FINAL DRAINAGE REPORT FOR

Claremont Business Park 2 Filing No. 1

EL PASO COUNTY, COLORADO

APRIL 2020

FINAL DRAINAGE REPORT FOR
CLAREMONT COMMERCIAL FILING NO. 3
COUNTY OF EL PASO, STATE OF COLORADO
PROPOSED DRAINAGE MAP

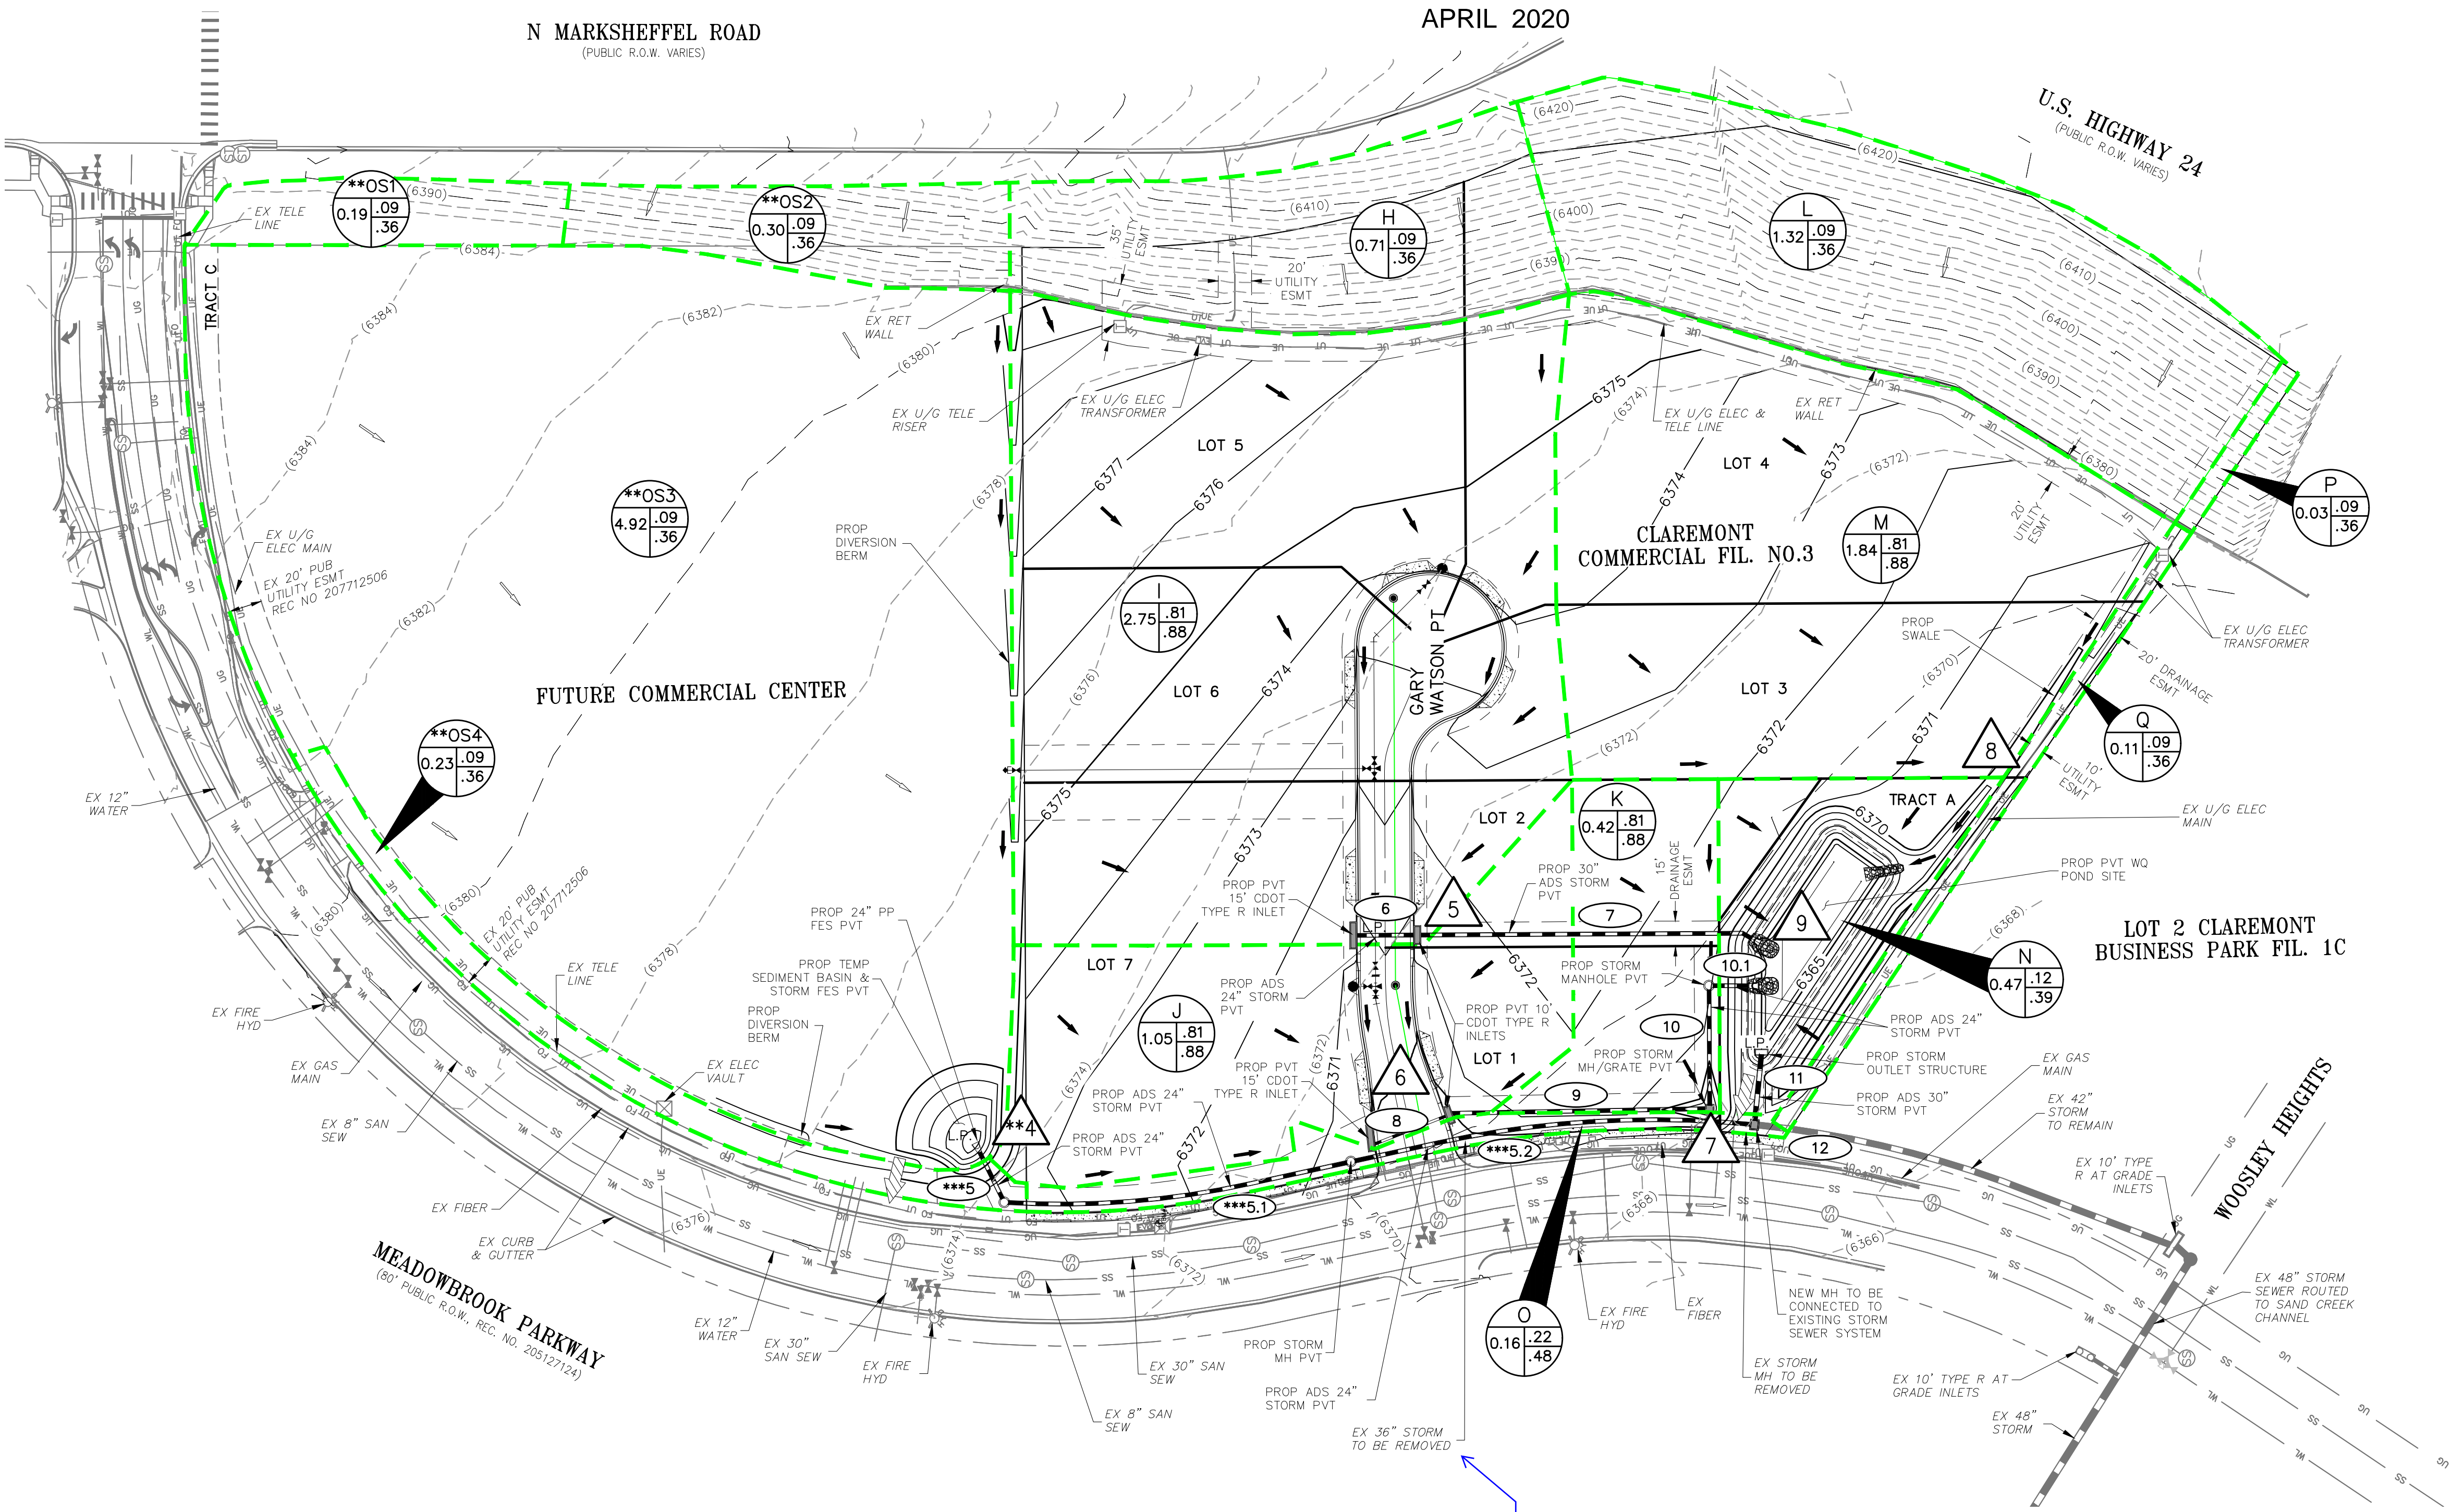
This RCP is not shown on the drainage plan. Will it be utilized by this development? will it be removed? Please address what will happen to this 30" RCP.

Please provide an existing drainage plan showing the appropriate basins and design points (Q) of the historic/existing drainage flow patterns.

Comment addressed called out on drainge plan.

Comment addressed Matrix FDR map DR01 is ex. conditions map.
